Our reference: P-387860-Q0C5
Contact: Kathryn Saunders, Principal Planner
Telephone: (02) 4732 8567

16 November 2022

**Modification Application - Aspect Industrial Estate
SSD-10448 - MOD-3**

Landscape Concept Masterplan

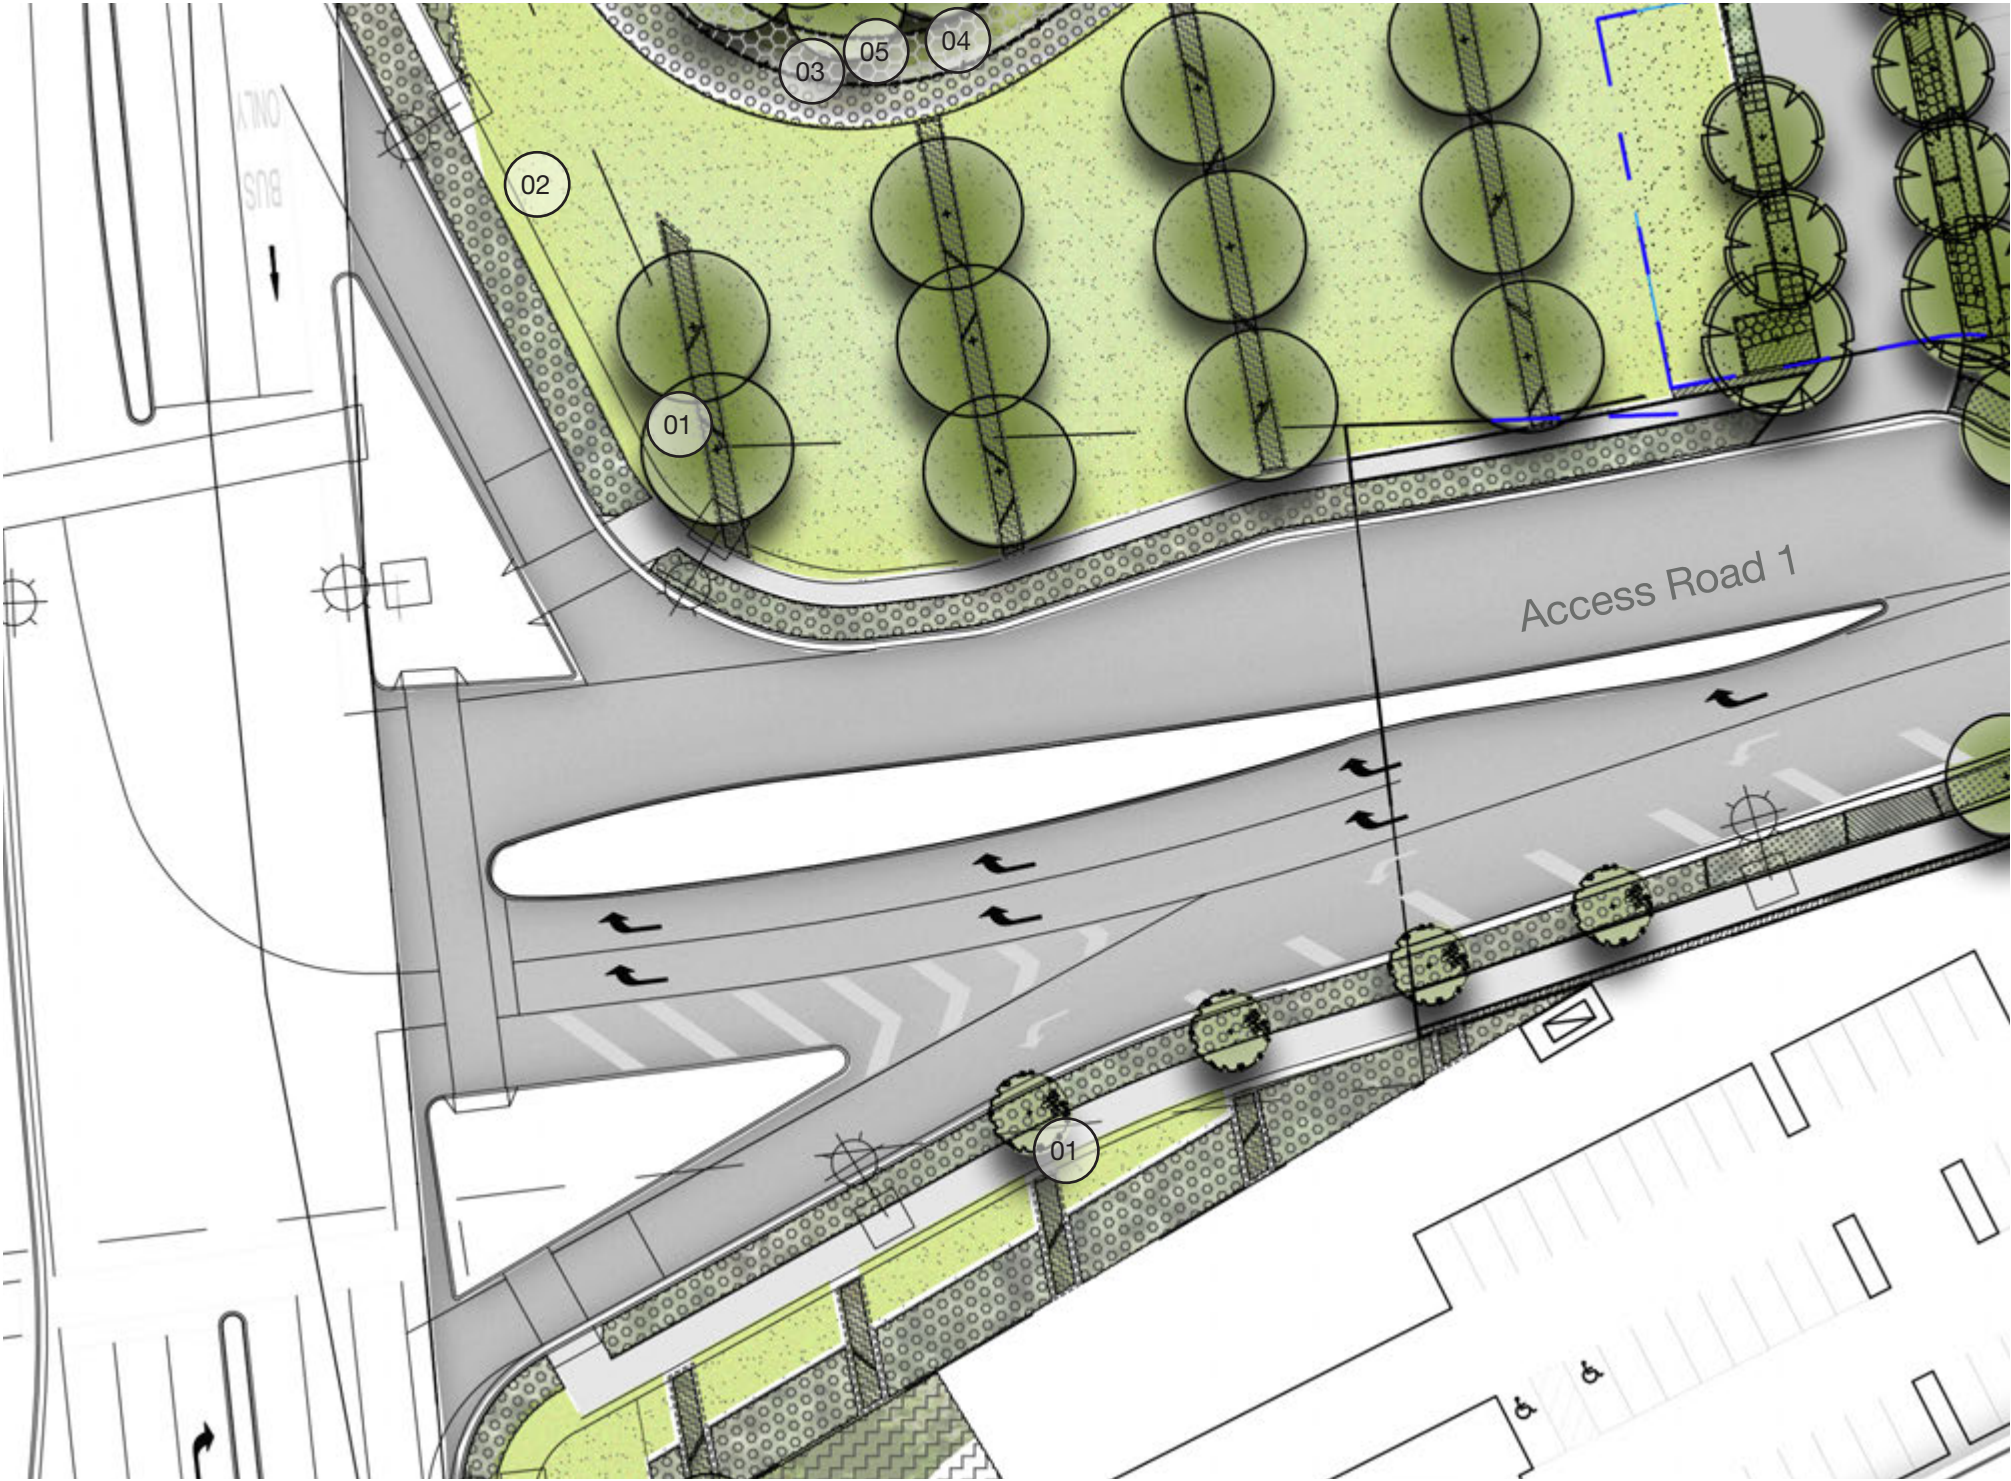
- (f) Street tree planting for all public roads is to be provided at 10m maximum centres and is to be shown on plans. The landscape master plan indicates limited street tree planting as noted below in yellow.

Civil sections indicate no planting at the boundary between Lot 1 and the basin maintenance track in conflict with the landscape plans (refer conflicting planting at Figure 1 and 2 below).

Section G 1:200

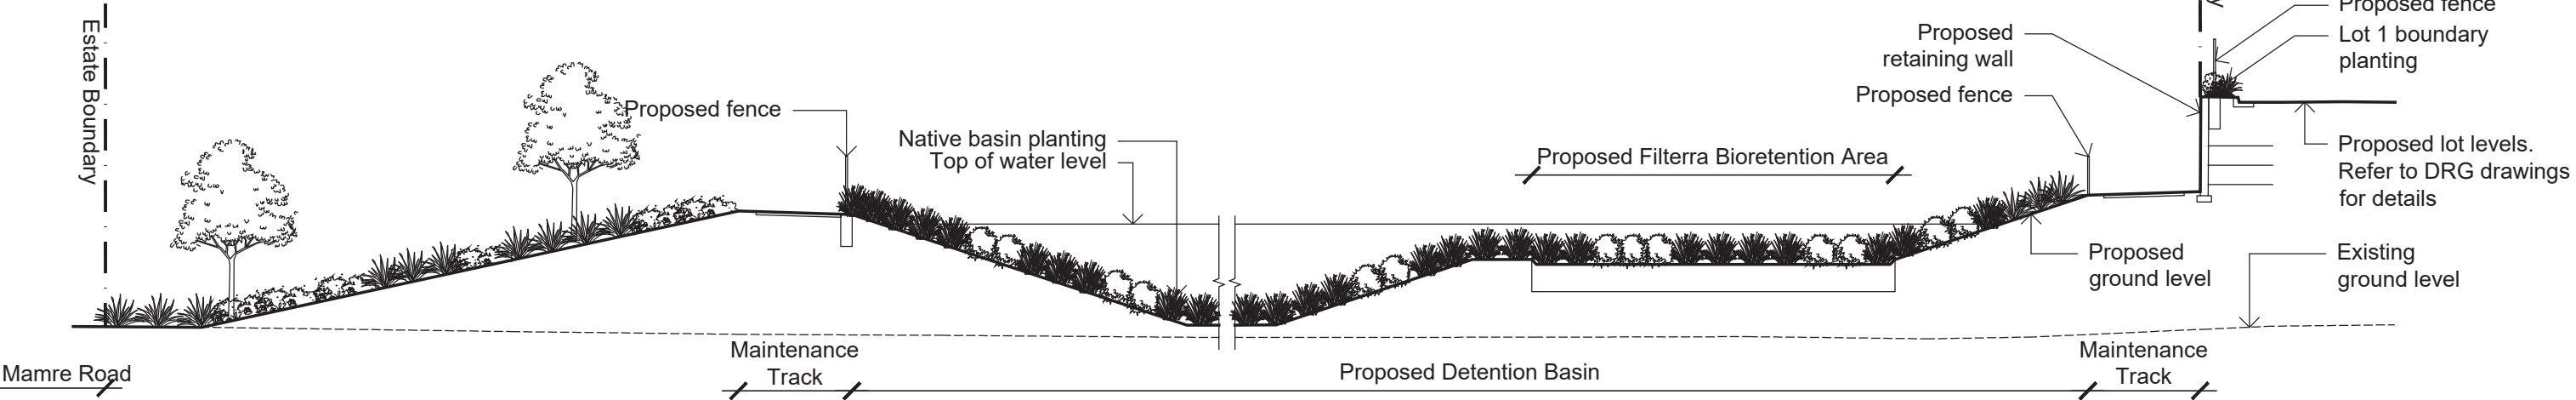
- (g) Tree pits within car parking spaces are to be staggered and not provided in rows. It is recommended that some areas within the central carparking aisles be designed to support a more significant cluster of trees which would assist in breaking up the apparent bulk of the warehouse building, would contribute to canopy cover targets and reduce heat island impacts. As excess car parking, this much needed design improvement is considered achievable.
- (h) Landscape Section G, on Site Image drawing 0013 does not reflect the tree planting on plan. Basin planting indicates trees are to be planted within the basin, although no tree species are indicated in the Basin Planting Schedule (same drawing) and trees are not included in the Basin Section G.
